Date: 12/13/2021

Re: **Inspection Item**
Location: Lot 227 Wood Grove (Fuquay-Varina, NC)
JDS Project No.: RDU2112843
Date of Inspection: 12/13/2021

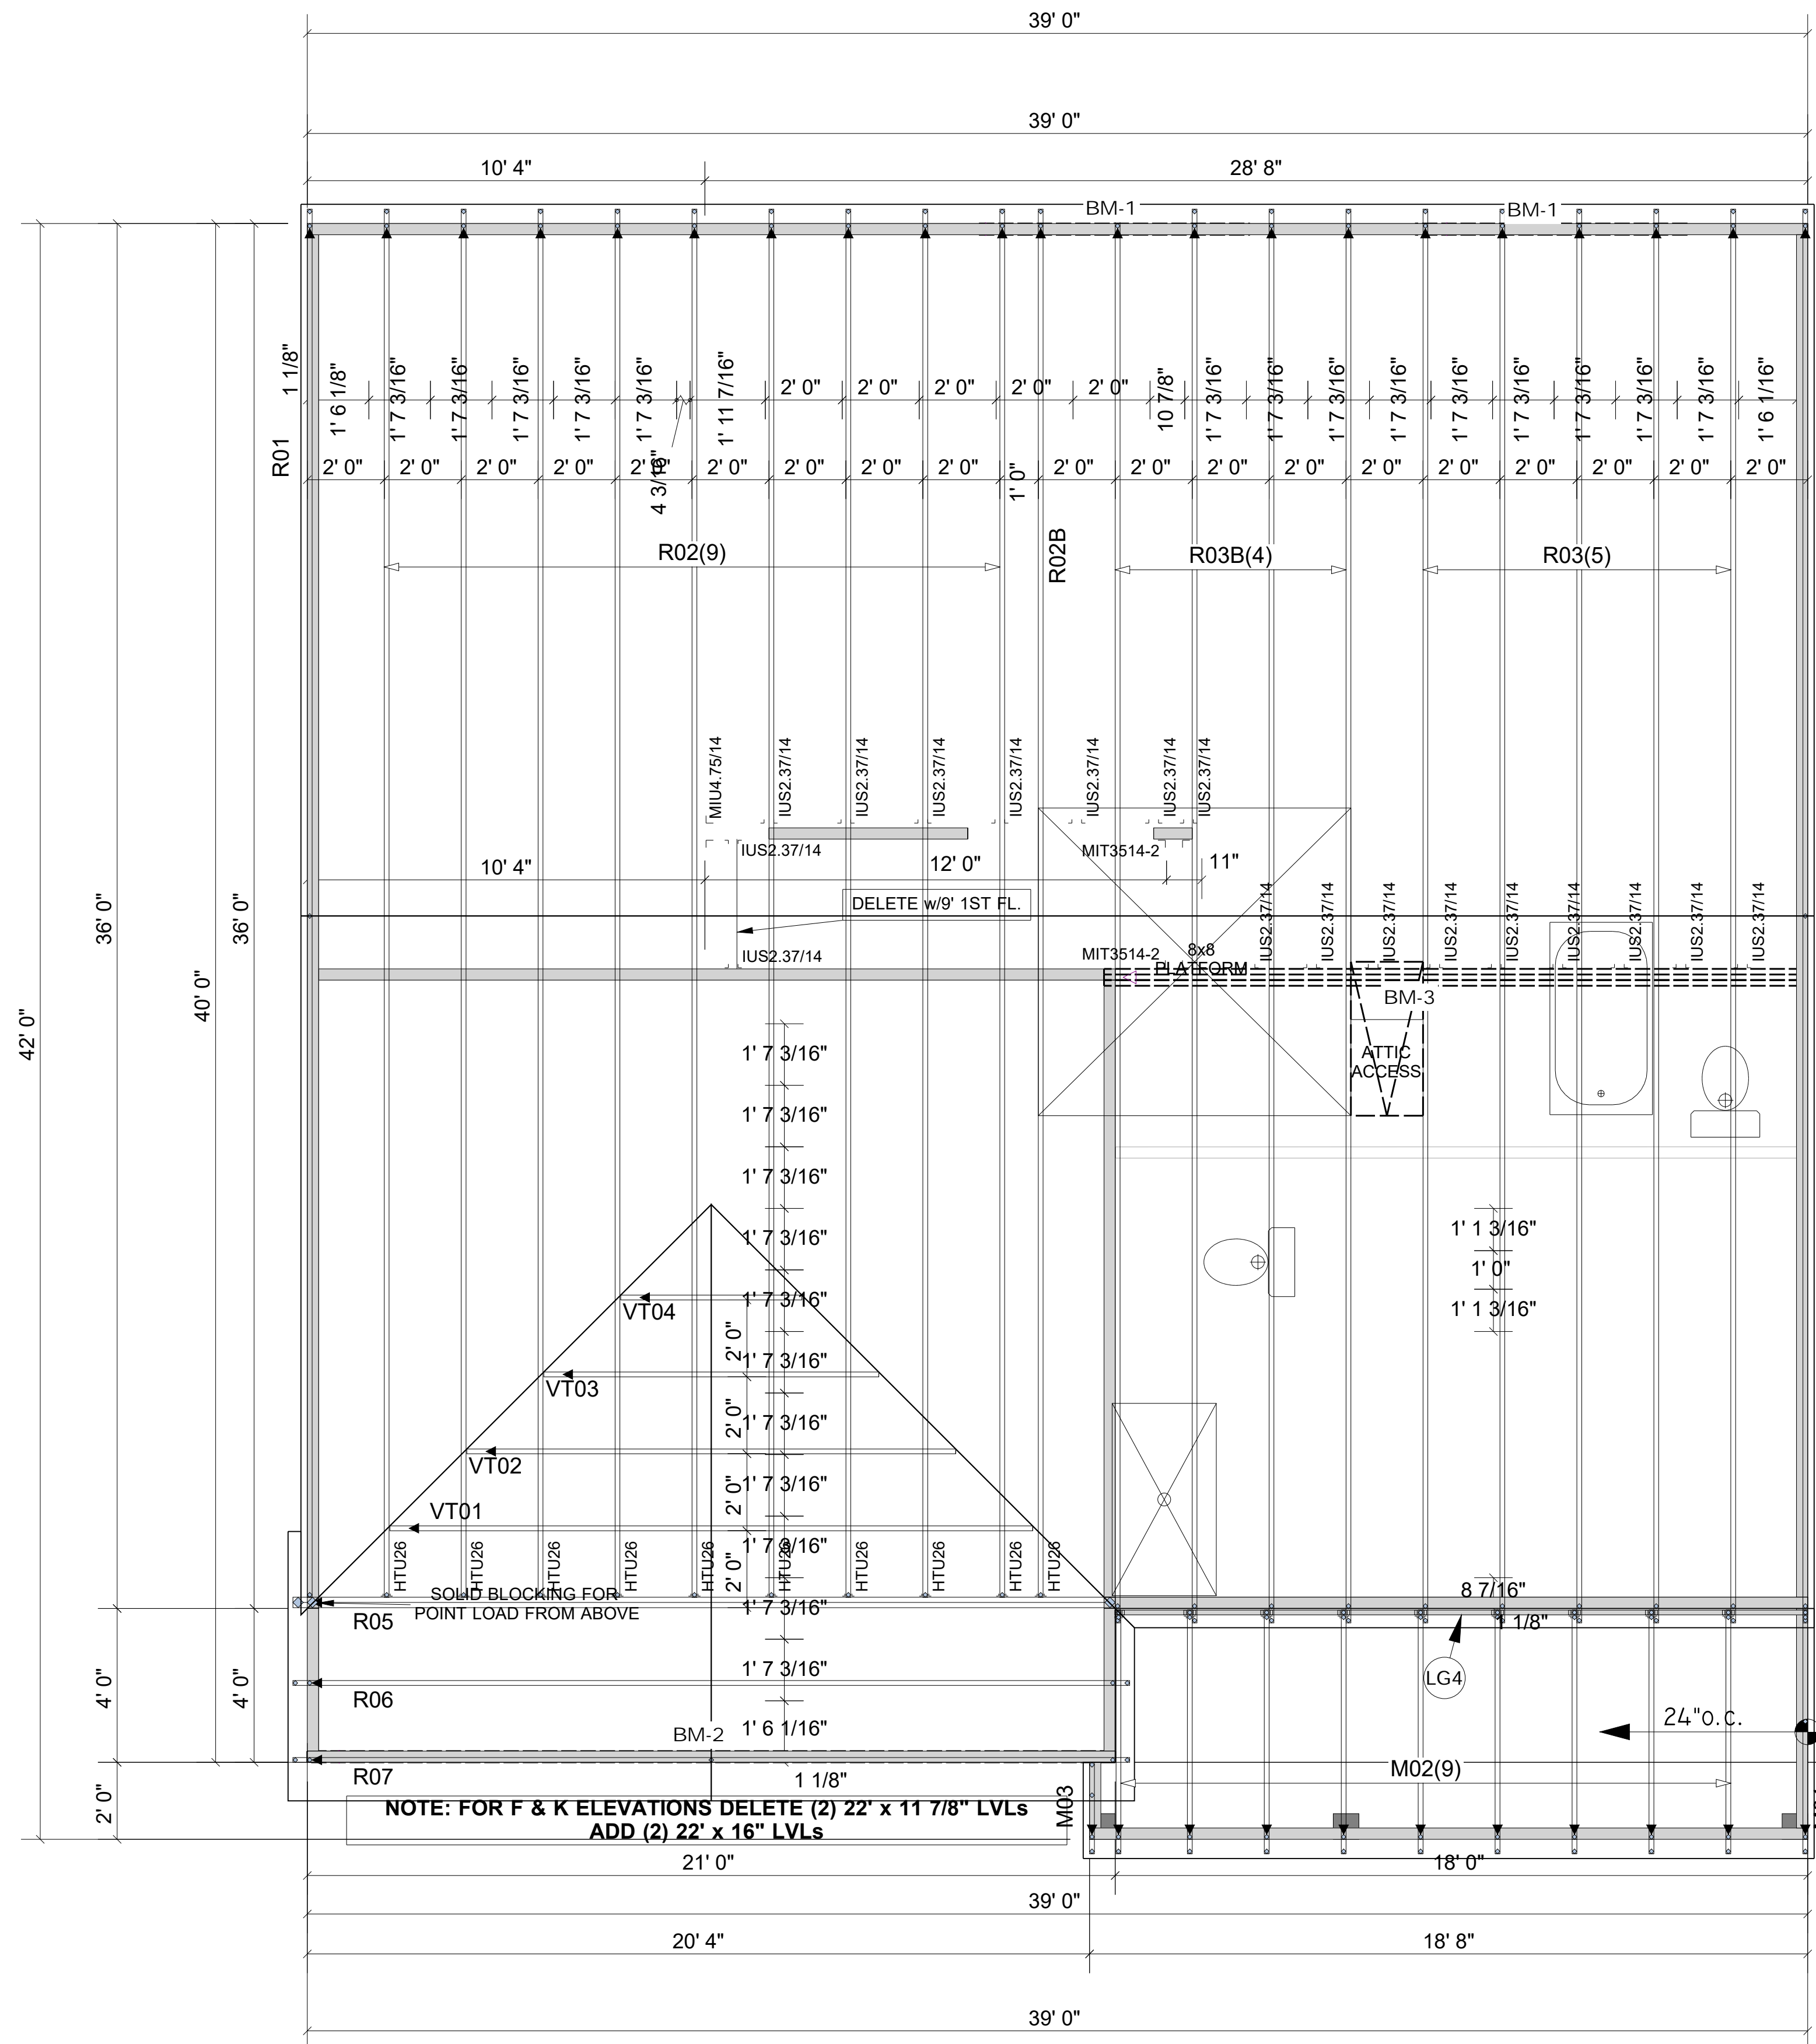
The client requested evaluation of the delaminating bottom flange of the I-joist located 3rd from the left of the J6 joist. The flange delamination occurs over an approximate 36" area beginning at the front bearing end.

- Temporarily support the I-joist and remove the hanger. Pack out the I-joists on both faces with 6' long ¾" OSB scabs beginning at the front end. Attach with construction adhesive and (3) 6d nails spaced 6" o.c.
- Install (1) 6' long 2x4 scab on both sides of the joist flush with the bottom flange beginning at the front end. Attach with (2) 10d nails spaced 6" o.c., with (1) in the web and (1) in the flange.
- Secure the I-joist with (1) Simpson HU5.125/11 or (1) Simpson HU5.125/14. Where gaps are present between the joist and the hanger, install 2x4 vertical blocking the remaining depth of the joist. Fasten into all covered members with (2) 10d nails spaced 3" o.c.
- Inject a wood glue into the delaminated bottom flange and secure with 1-1/2" long wood screws spaced 6" o.c. Pre-drill all holes prior to attaching screws to prevent splitting.
